From: Michael Eastham <Michael.Eastham@arun.gov.uk>
Sent: 17 April 2020 18:15
To: Planning.Responses <Planning.Responses@arun.gov.uk>
Subject: FW: BN/85/19/DOC - The Lillies

Please upload the email below from ADC Drainage onto Ocella for the discharge of condition application BN/85/19/DOC at The Lillies, Yapton Road, Barnham.

Subject: RE: BN/85/19/DOC - The Lillies

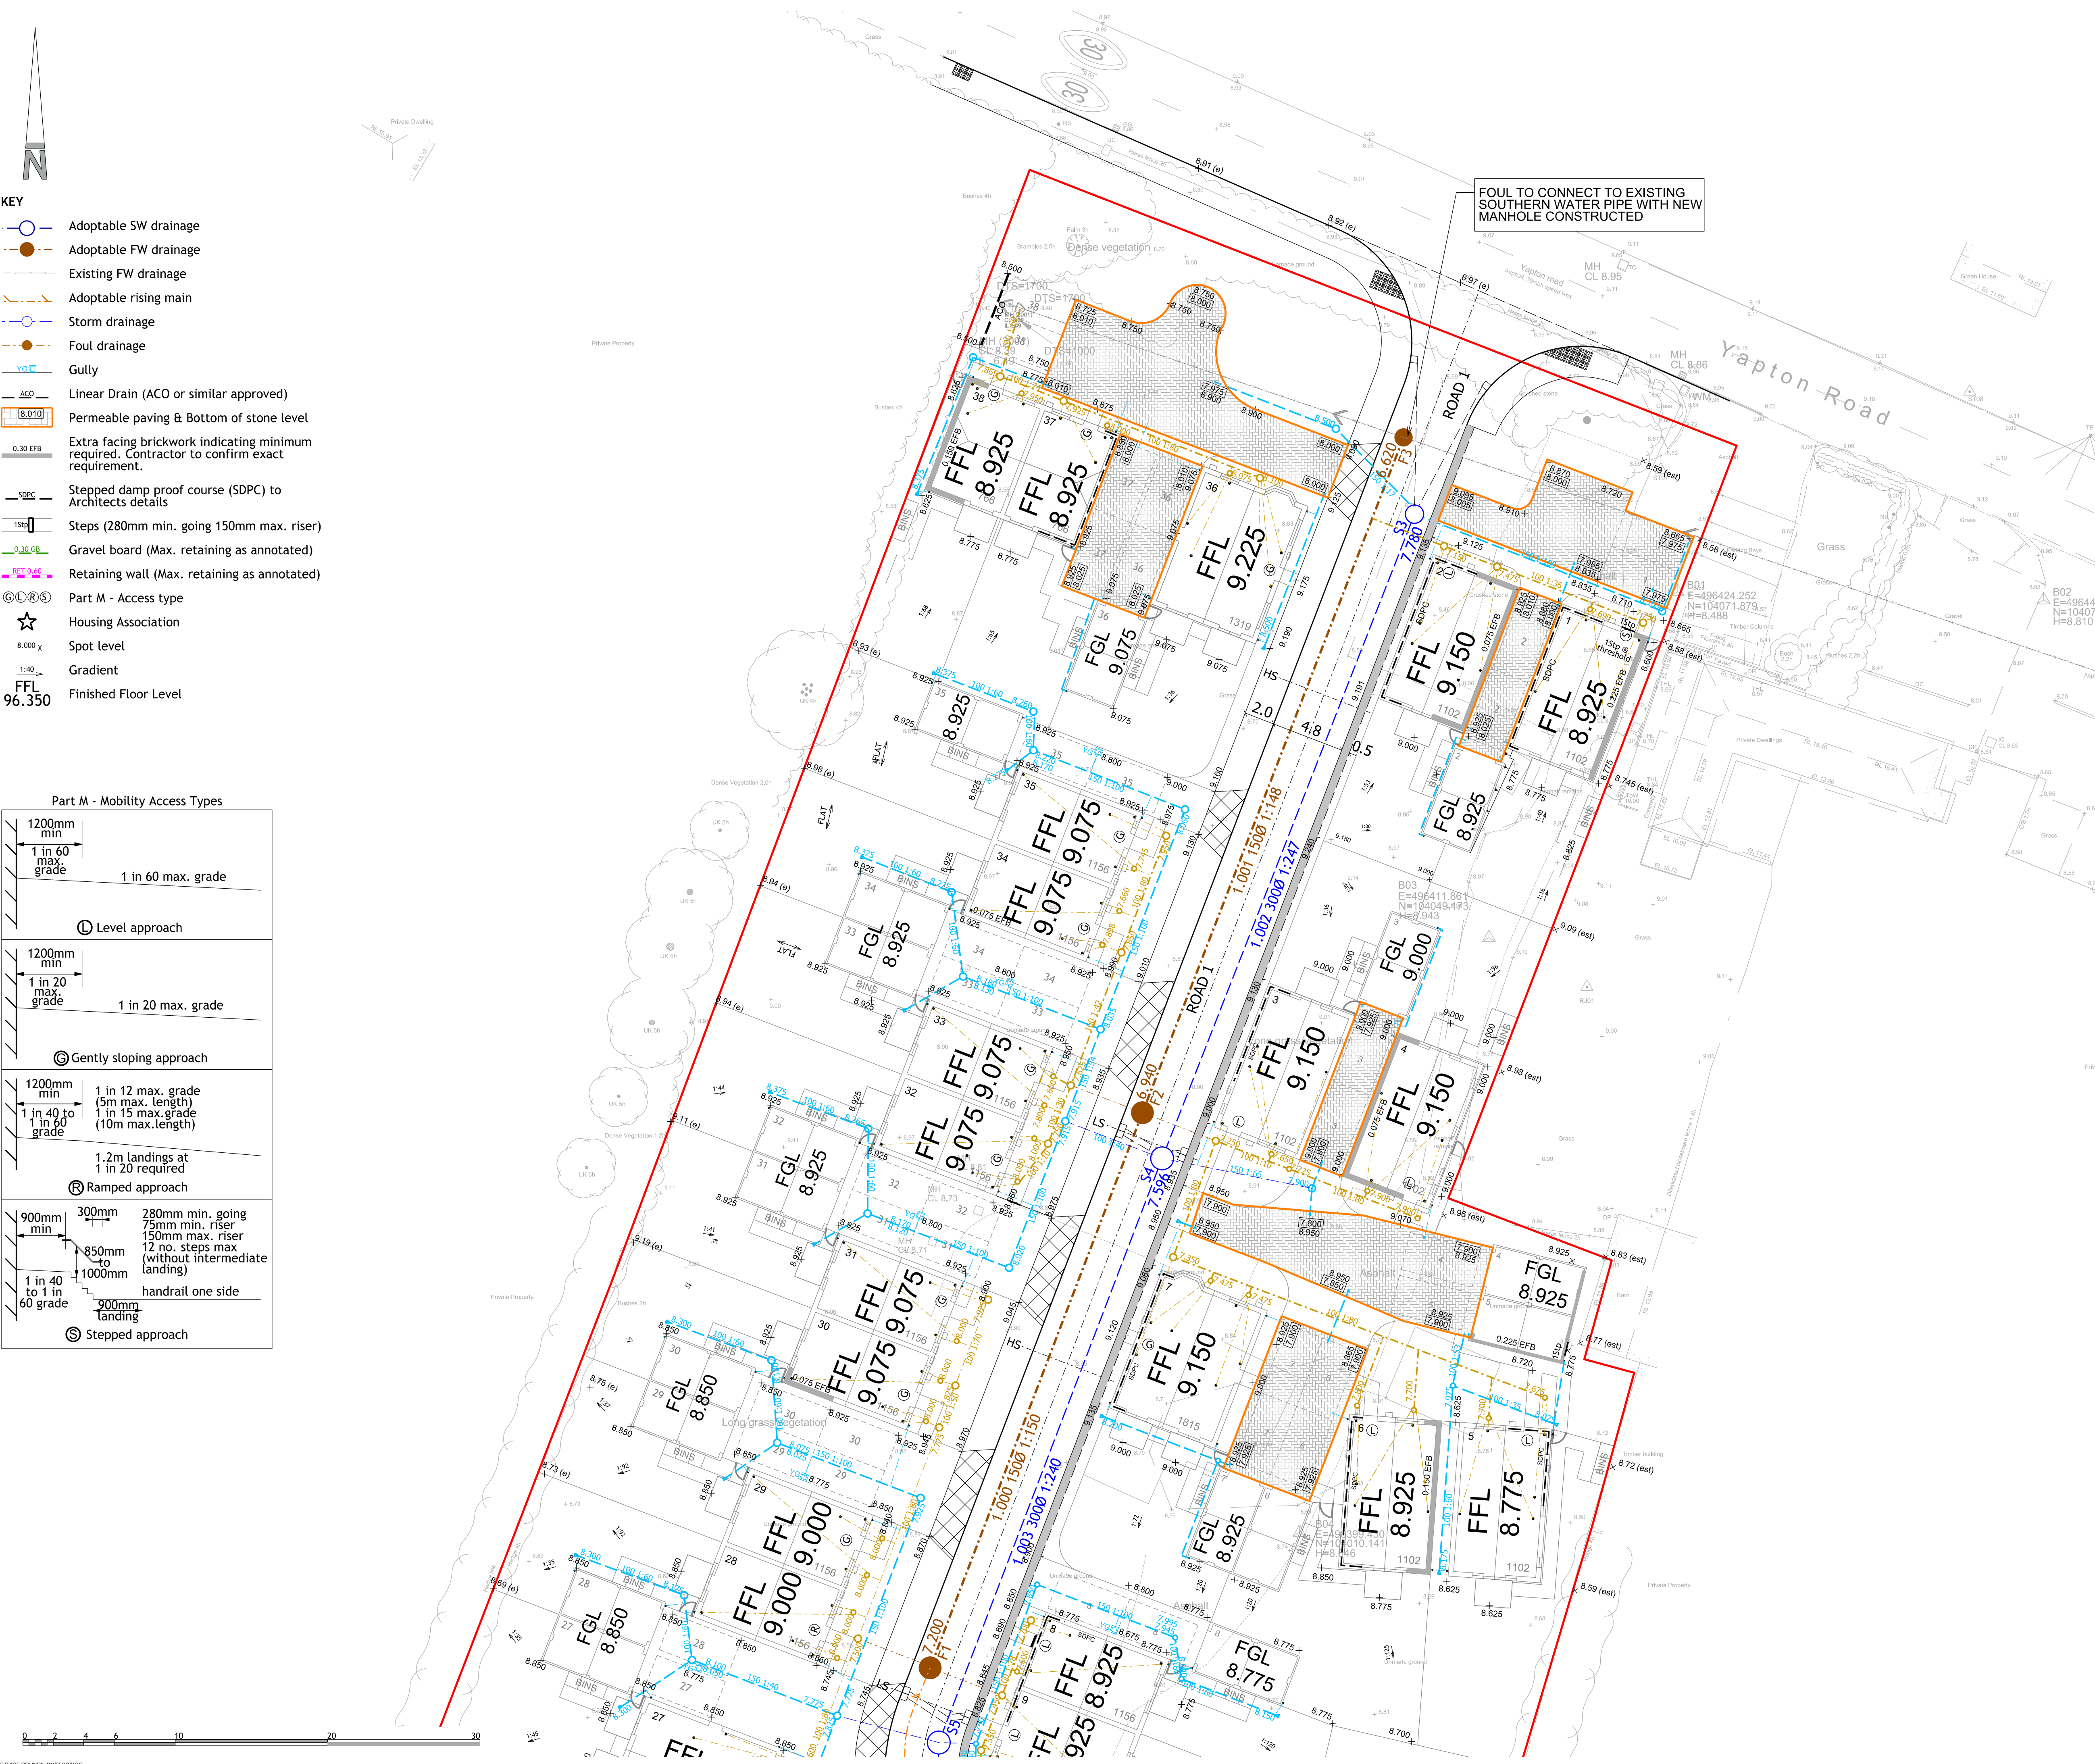
1. Please forward Southern Waters comments on the proposals in terms of adoption.
2. Noted ok but add a 3 metre dimension line/note on the plan so it is clear to the contractor.

3. Note 11 added but include reference to this note, by the footpath on the plan. I.e. See note 11, so the contractor is completely clear on this.
4. Ok

41. Some domestic manholes on the plan have a cross within ie. orifice control manholes. Add these to the drawing key/legend. I note the orifice control manhole construction detail. This needs to be fully detailed ie. similar detailing to Type B manhole, ie. concrete surround to rings, brickwork courses under frame, etc. You will need to check that this construction is suitable based upon the proposed depths. Orifice diameters appear to range between 50 and 100mm diameter? Make this very clear on the layout plan/construction details. Any orifices less than 100mm diameter require protection against blockage (if they are receiving direct flows from anything other than the outlet from permeable paving). I note that you propose a trash screen . This will need to be fully detailed, however, I would suggest a perforated filter arrangement instead.

TYPICAL CROSS SECTION ACROSS PERMEABLE BLOCK PAVED DRIVES INCORPORATING IMPERMEABLE BLOCK PAVED SERVICE CORRIDOR

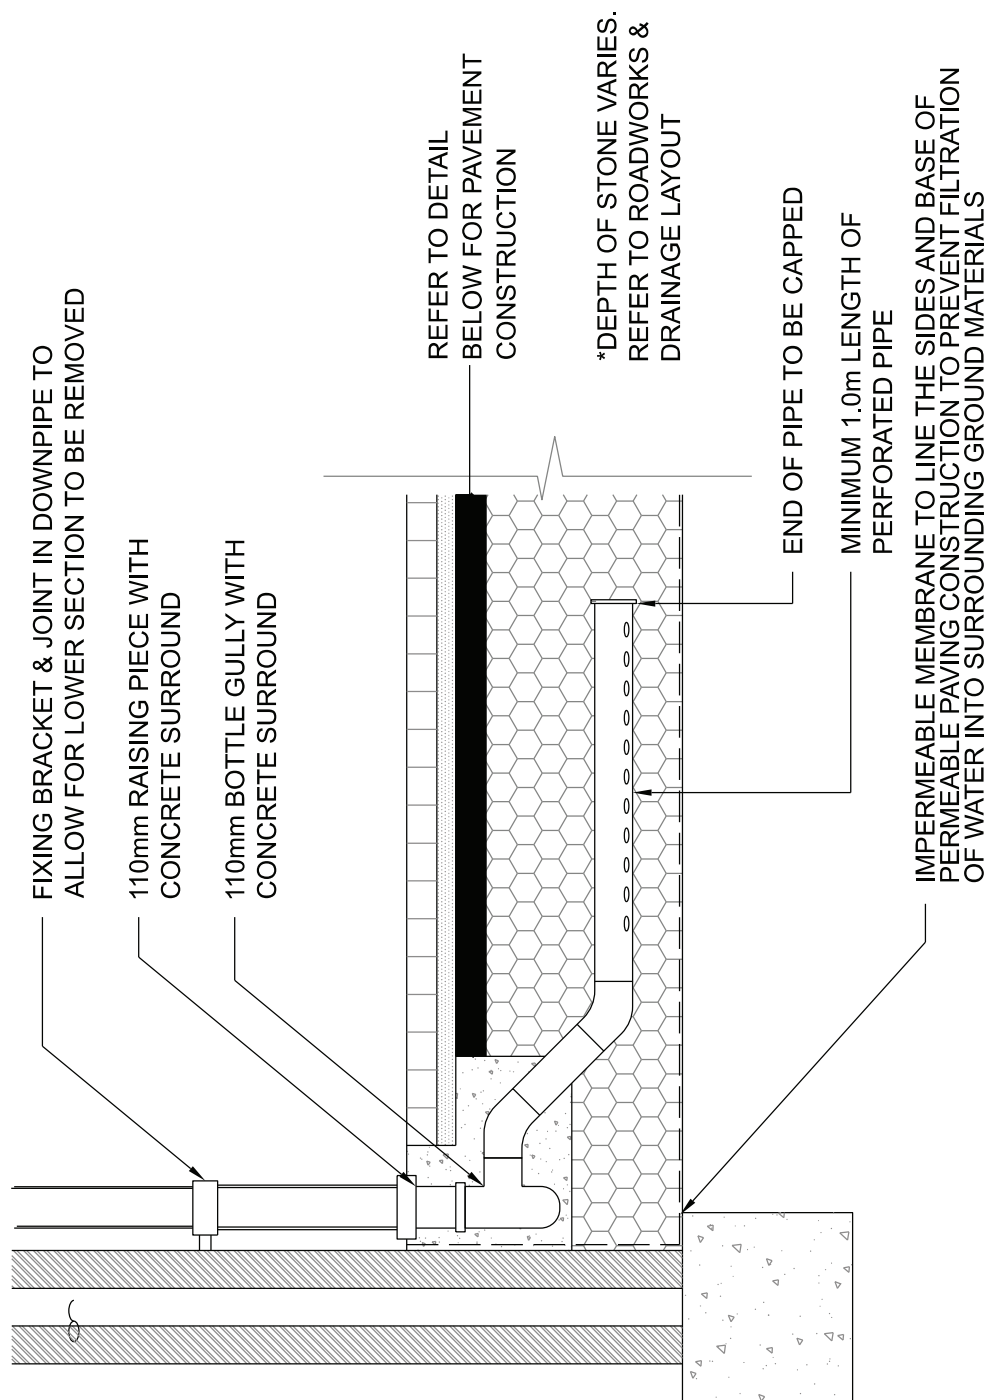
7. See above.
8. Ok
9. Ok
10. All permeable paving link pipes need diameters and invert levels specified + see item 6 above.
11. Ok
12. Ok but specify width of construction. How is water able to pass through the permeable pavement either side ie. through the standard construction which is in effect causing a dam?

'Cranked' grille to suit a 450mm pipe

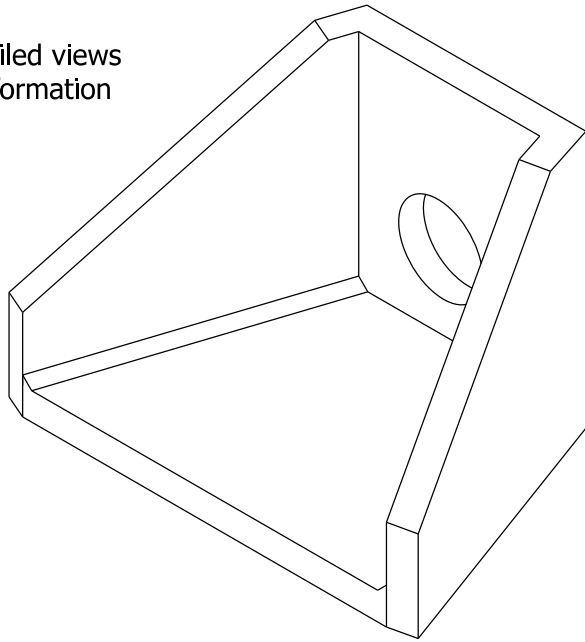
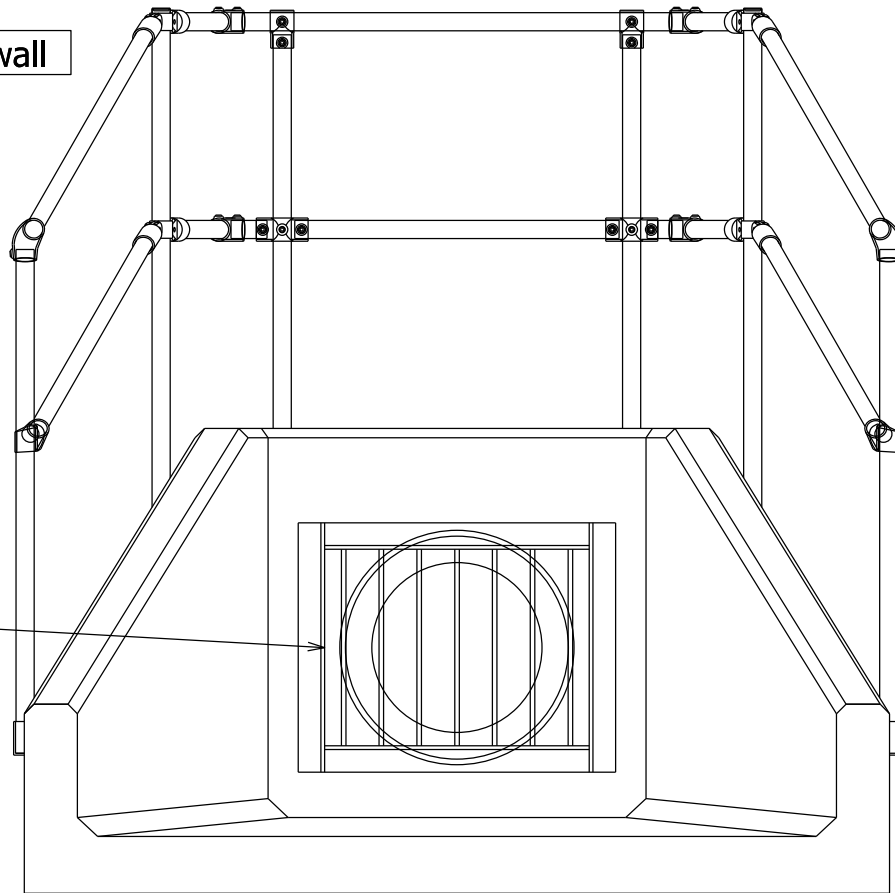
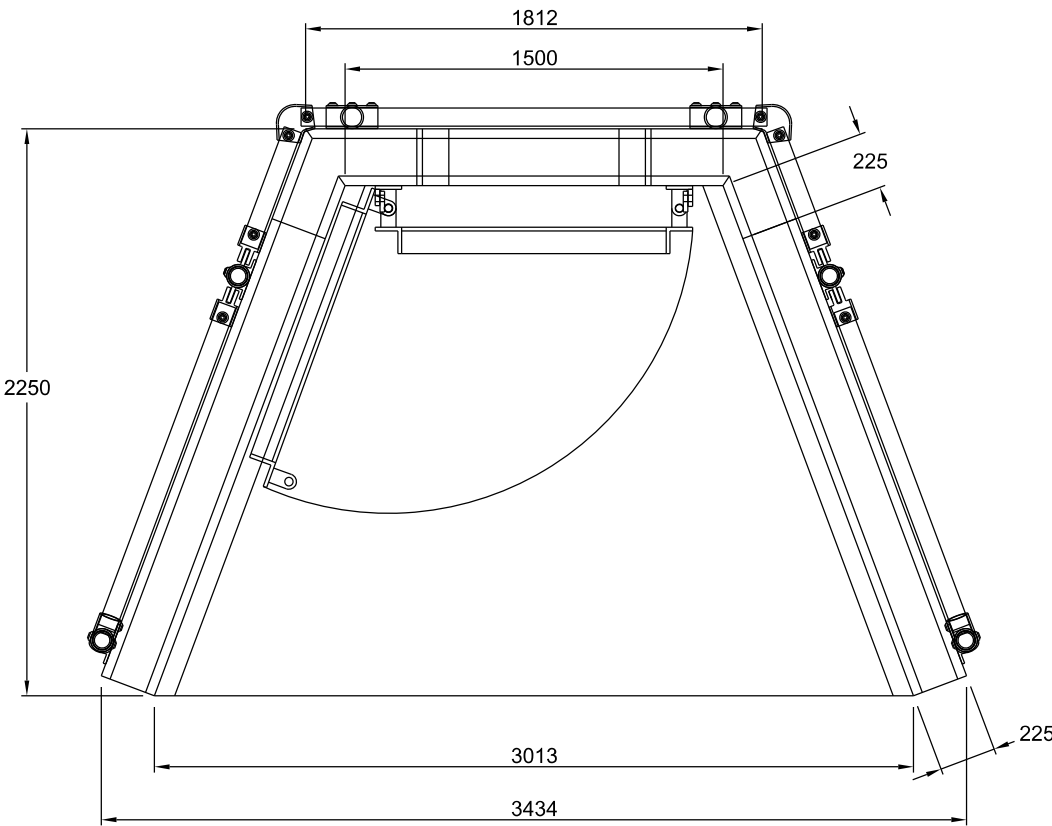
26. Ok
27. Ok
28. Note added about cranked grille but drawing still shows a flat grille. Please adjust. Sorry – the cranked grille arrangement needs to apply to both headwalls. Couldn't see the note 'Banks in vicinity of headwall to be profiled to suit wing walls' – sorry this is also applicable to both headwalls - please advise.
